Sent: 14 December 2011 16:44
To: Planning
Subject: Planning application S6/2011/2513/FP - 67 The Ridgeway

Response to Planning application from Hertfordshire County Council (T and CP GDP Order 1995)

District ref: S6/2011/2513/FP
HCC ref: WH/349/2011
HCC received: 02/12/2011
Area manager: James Dale
Case officer: Lindsey Lucas

Erection of boundary wall and gates

P2	plans added + scale bars	17.11.11
REV	DESCRIPTION	DATE
67, RIDGEWAY, CUFFLEY HERTFORDSHIRE EN6		
PROPOSED NEW FRONT WALL AND GATES		
Scale @ A1	1:50, 1:200	
Created	OCT 2011	
Purpose of Issue	PLANNING

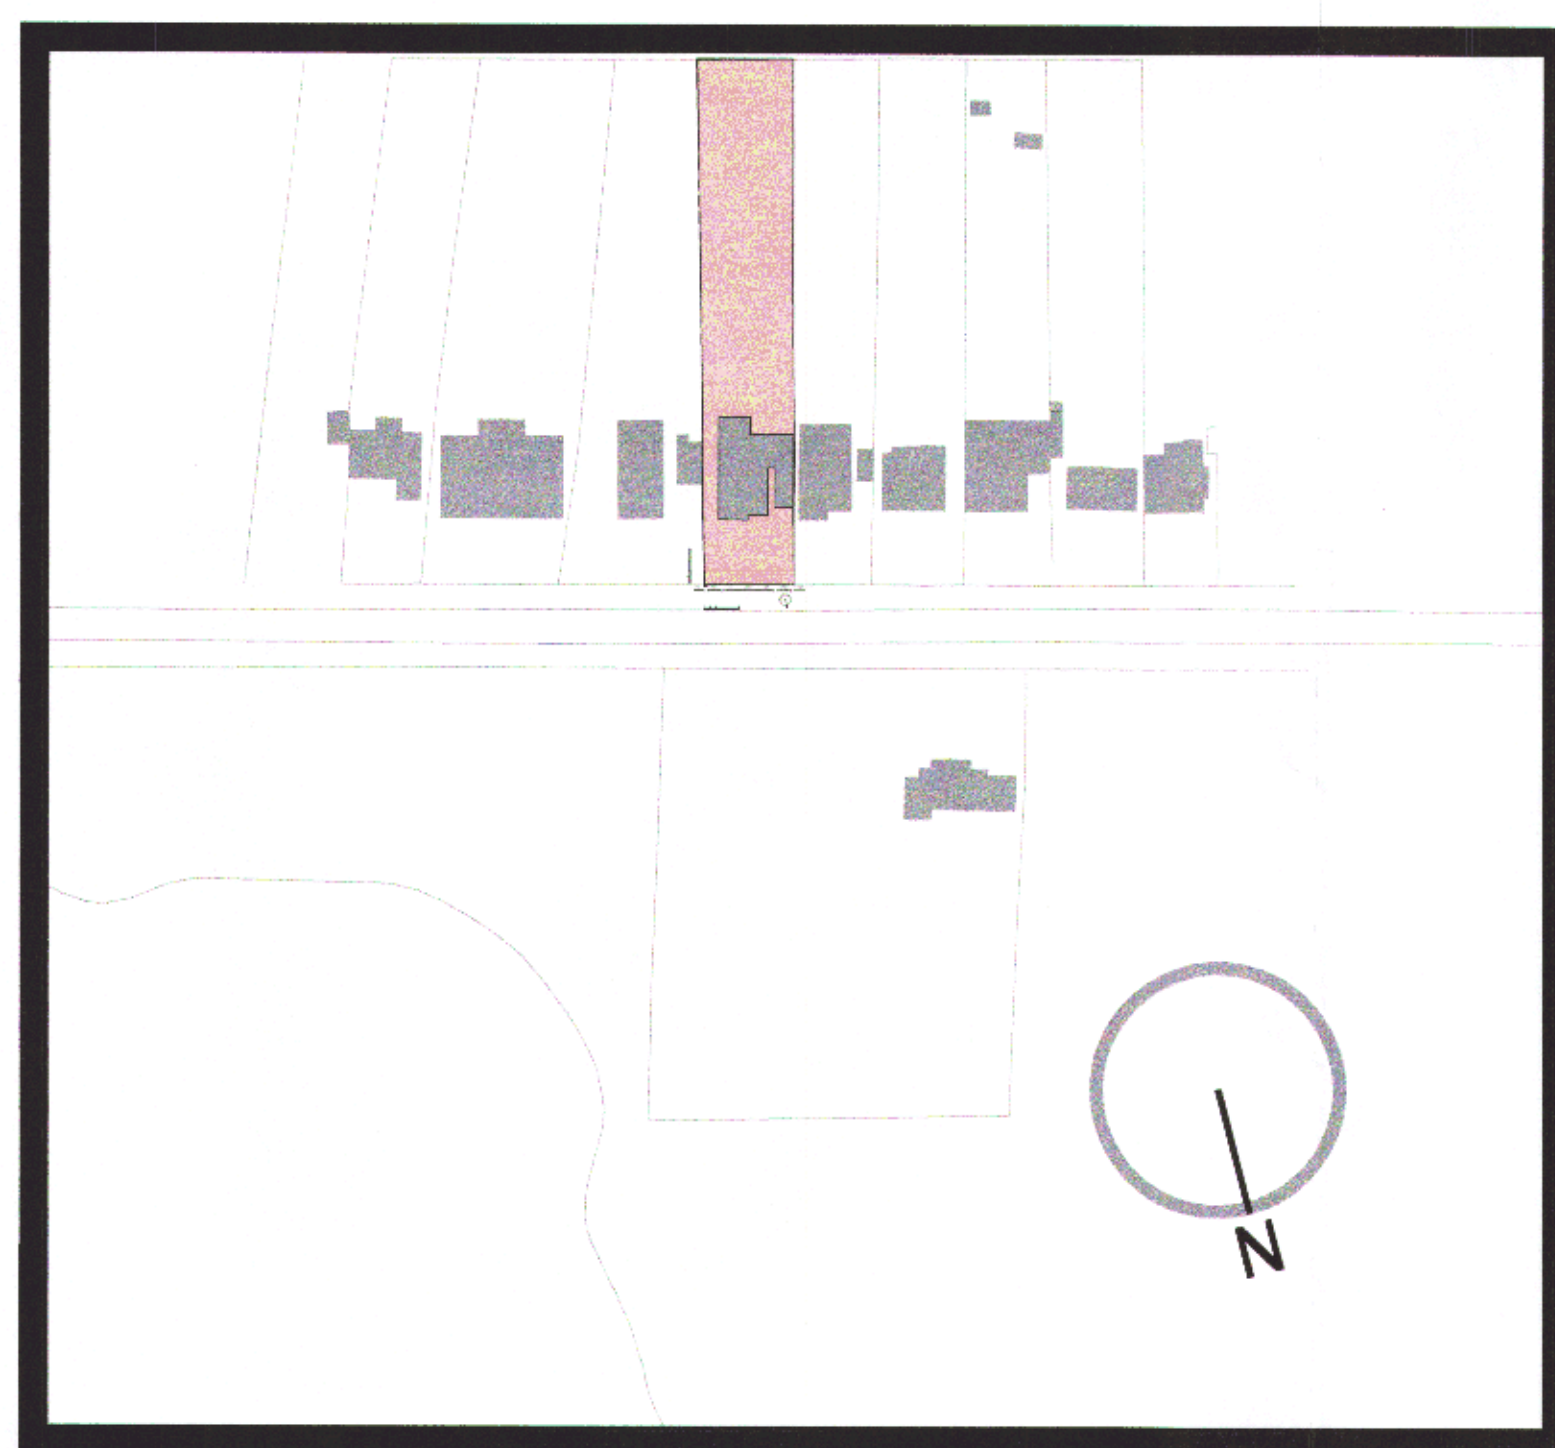
1. C.8.10 -Any gates to be provided shall be set back a minimum of 5.0m from the edge of carriageway and shall open inwards into the site.

COMMENTS: This application is for the installation of a new boundary wall and gates. The plans do not show the distance between the gates and the edge of the carriageway hence the need for the inclusion of the above condition. Several of the neighbouring properties are gated and these gates appear to be set back 5m from the edge of carriageway. This will just allow a vehicle to wait off the carriageway whilst the gates are opened and closed. The Ridgeway is a classified road, the B157 and is designated as a secondary distributor road. Hertfordshire County Council as Highway Authority considers the proposal would not have an unreasonable impact on the safety and operation of the adjoining highways subject to the inclusion of the above condition.
